Case Officer: Sarah Greenall

Recommendation: Approve

Proposal: Erection of stand alone garden studio and change of use of land from allotment to residential garden

PROPOSED ELEVATIONS

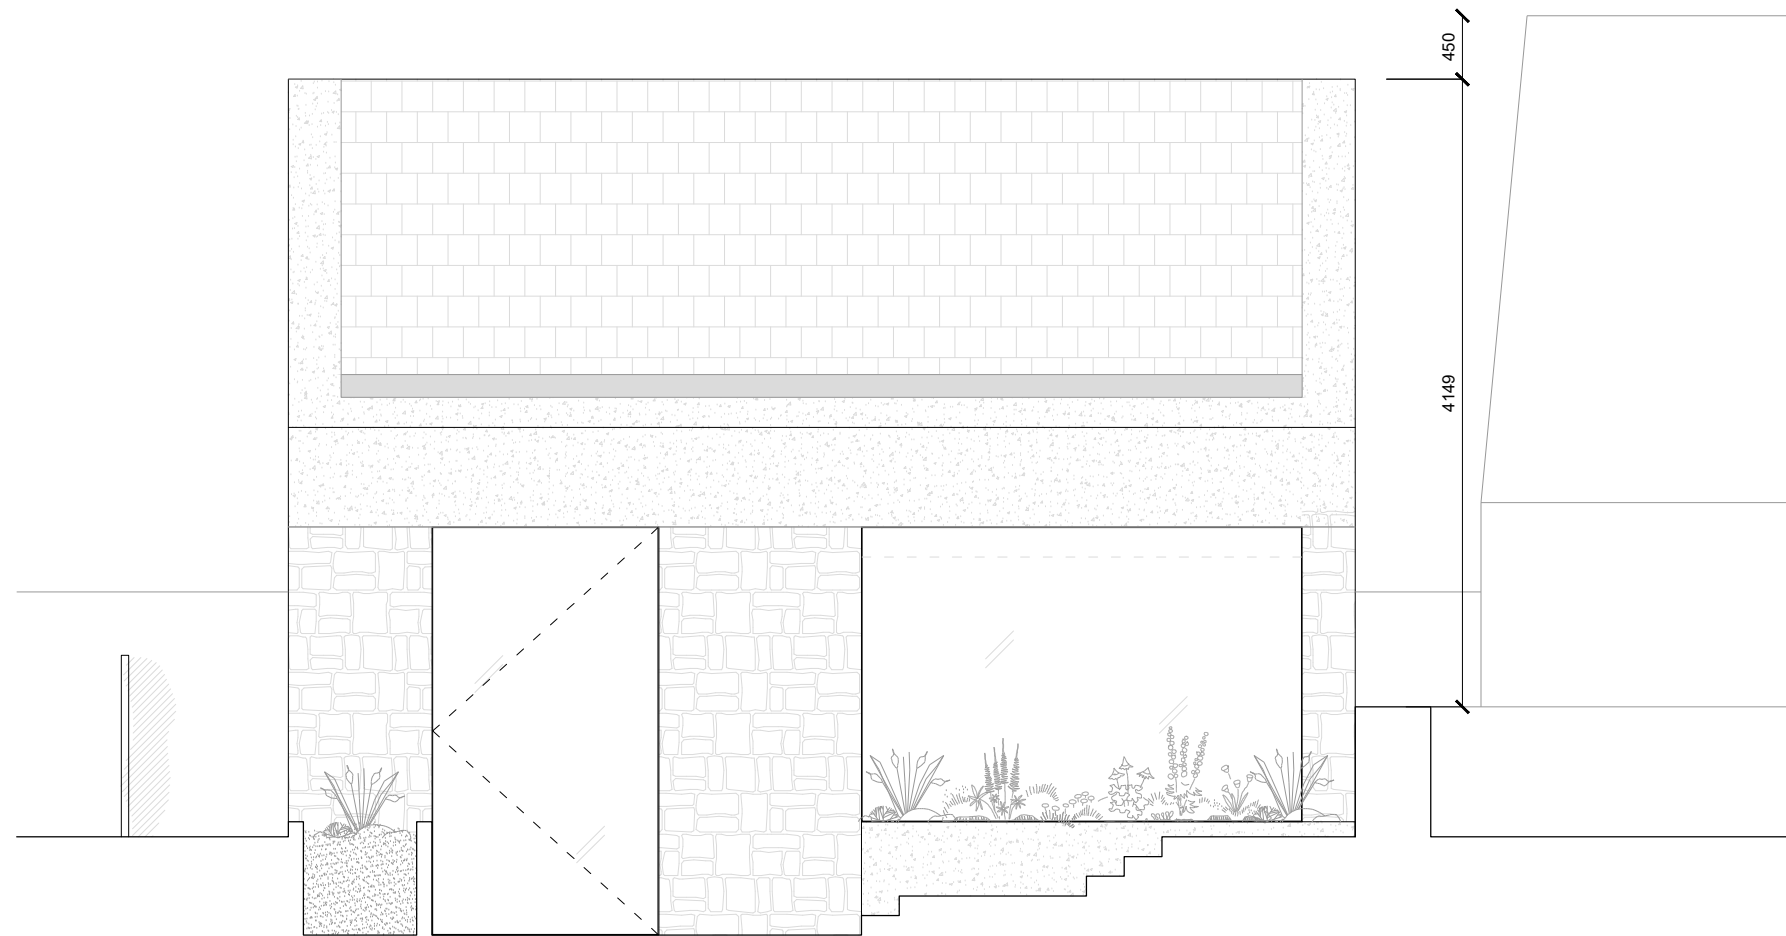
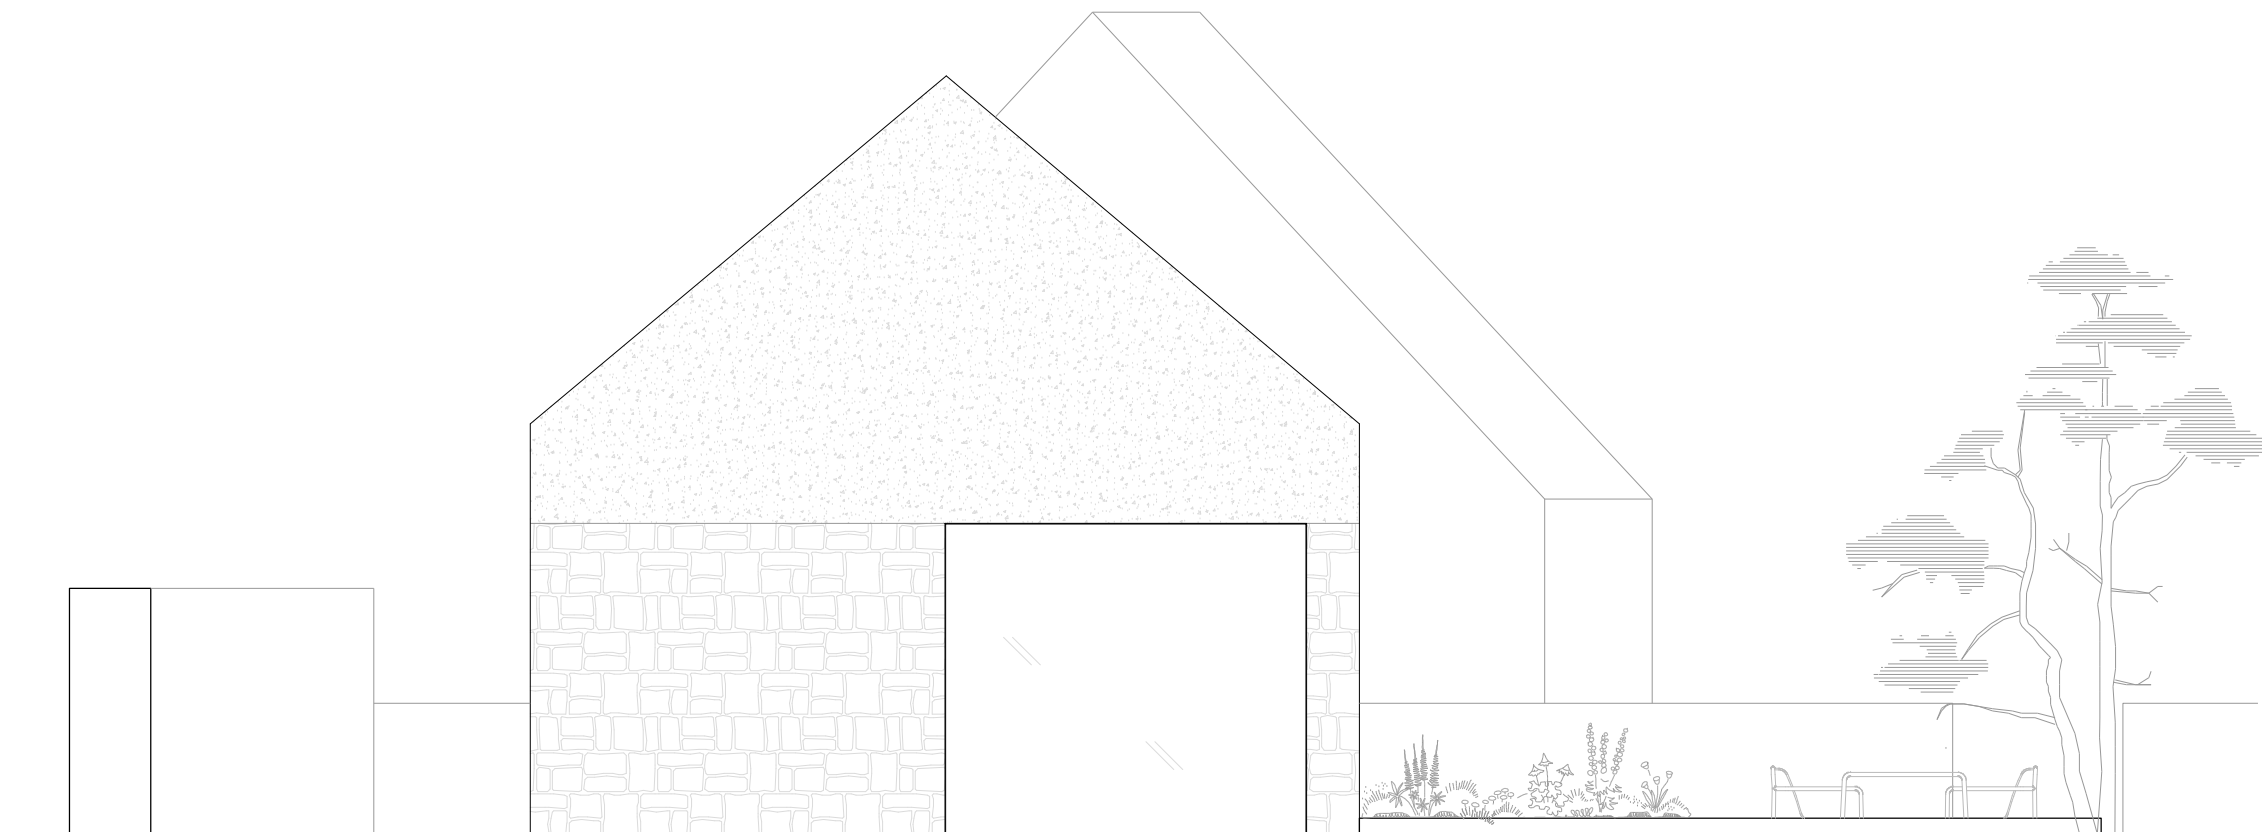
- 6.3. Conservation (CDC): **No objections** subject to conditions re windows and door details, slate sample and details, stone sample panel (which should be notwithstanding the details submitted to ensure that the mixture of two different stones for wall and gable ends are considered appropriate for the setting) and landscaping plan showing layout around the building.

- 8.16. The proposals have been amended prior to submitting the planning application and the building is now designed to have a rectilinear form that would be subservient to the host dwelling and neighbouring outbuilding. The principal elevation is orientated back towards Chancel Cottage with the gable ends facing Fir Lane to the west and the allotment fields to the east, which is in keeping with the general layout of outbuildings seen within the conservation area. The building is also proposed to be finished in Cotswold Stone that would match the materials seen on the main dwelling, with a slate roof to fit the character of surrounding outbuildings as previously suggested by the Conservation Officer.

5. Notwithstanding the details submitted, no development above slab level shall take place unless and until a sample panel of the materials to be used in the construction of the external surfaces has been prepared on site for inspection and approved in writing by the local planning authority. The sample panel shall be at least 1 metre x 1 metre and show the proposed material, bond and pointing technique. The sample panel shall be constructed in a position that is readily accessible for viewing in good natural daylight. The development shall not be constructed other than in accordance with the approved sample, which shall be laid, dressed, coursed and pointed using a lime based mortar and shall not be removed from the site until completion of the development. The development shall be retained as such thereafter.

PROPOSED ELEVATIONS

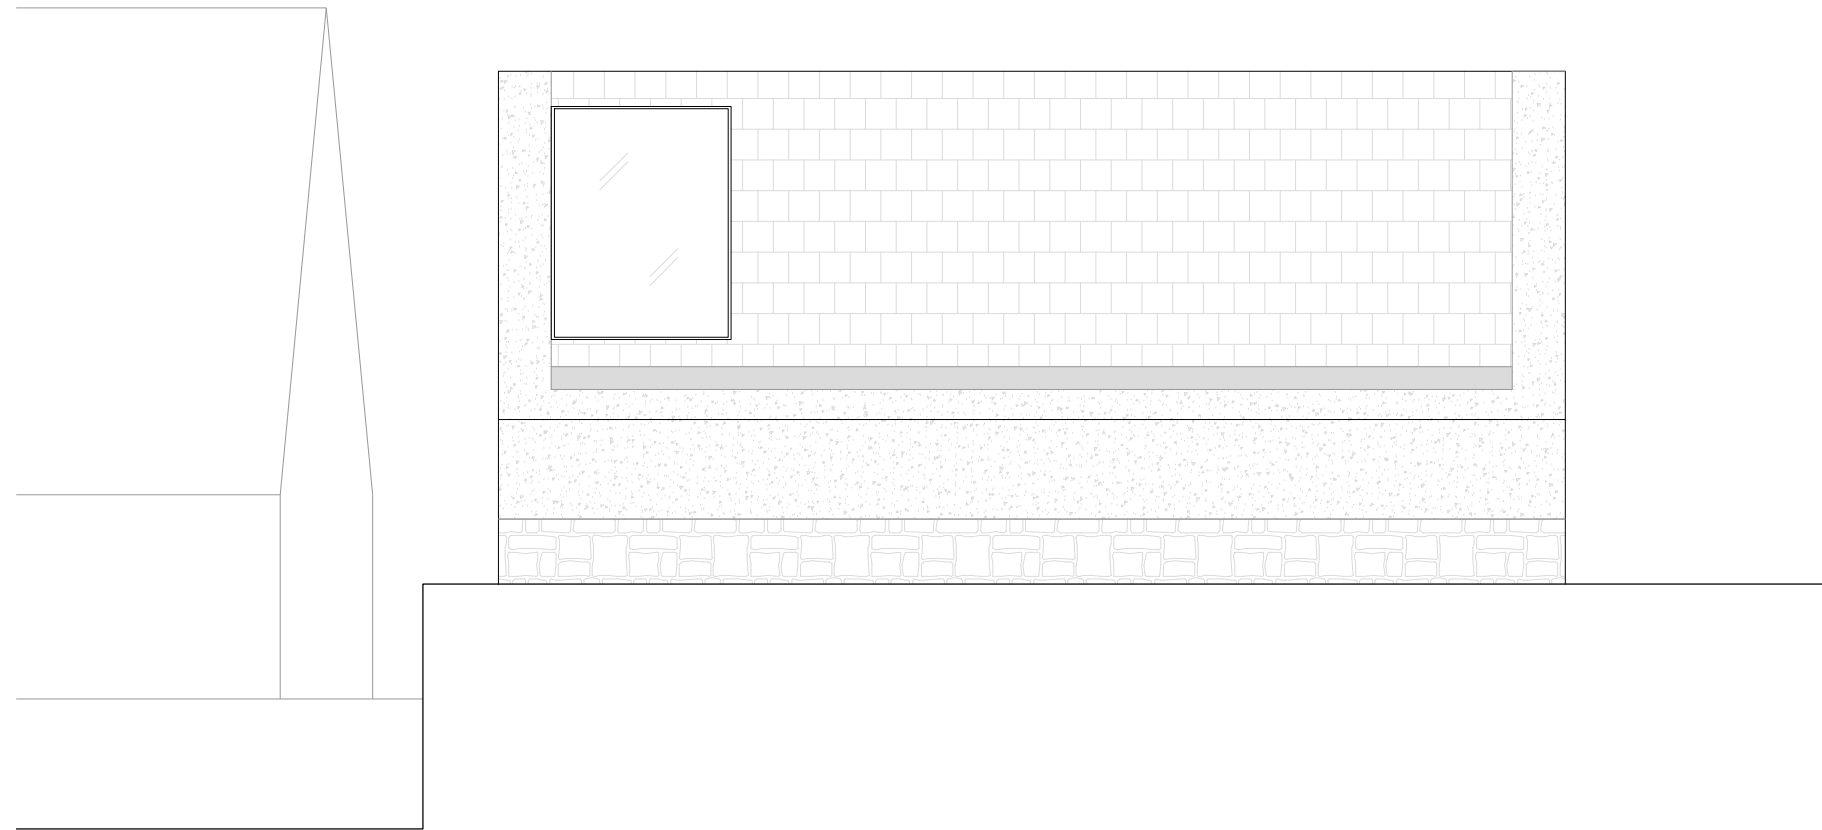
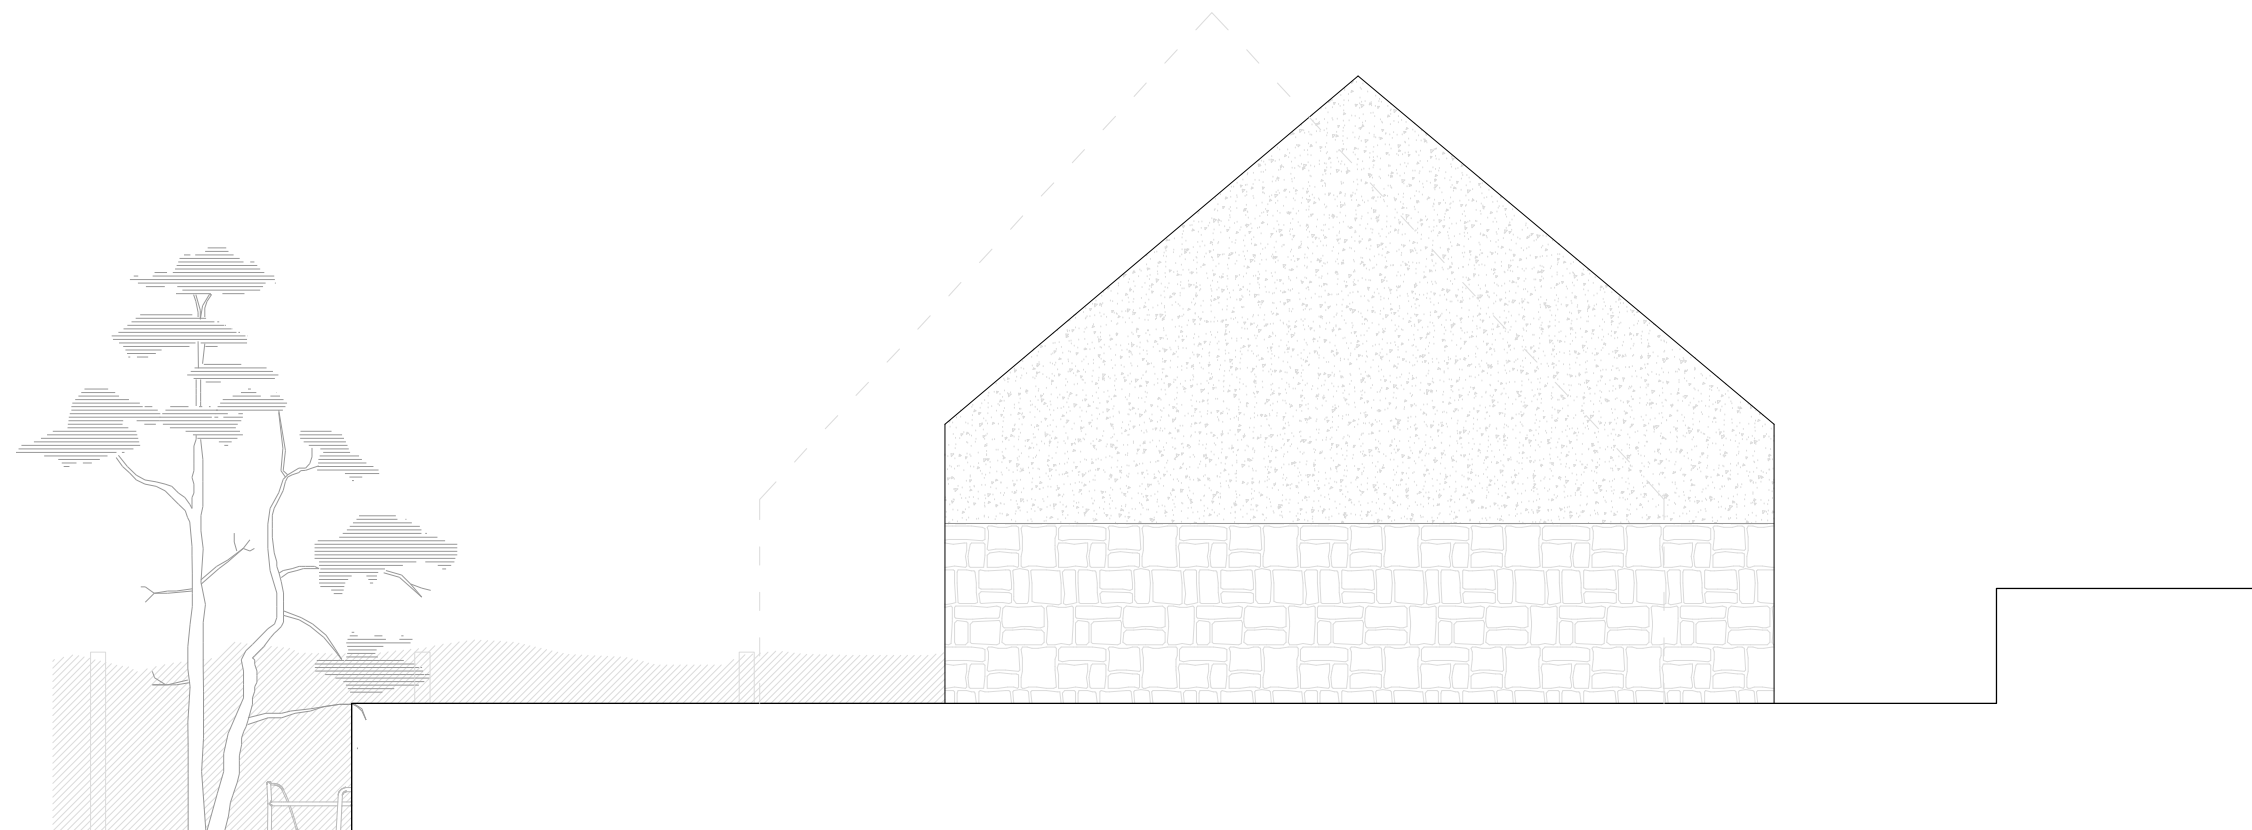
- 8.21. Given the positioning of the outbuilding, the only neighbour likely to be impacted by the development would be The Longbyre, located to the south of the site. The proposals are, however, single storey in nature and given the neighbour is located to the south of the application site it is not considered there would be any detrimental impacts on the light or outlook amenity of The Longbyre. Further to this, there are no windows proposed on the southern elevation of the building that would face towards this neighbour, and the impact on privacy would also be acceptable.
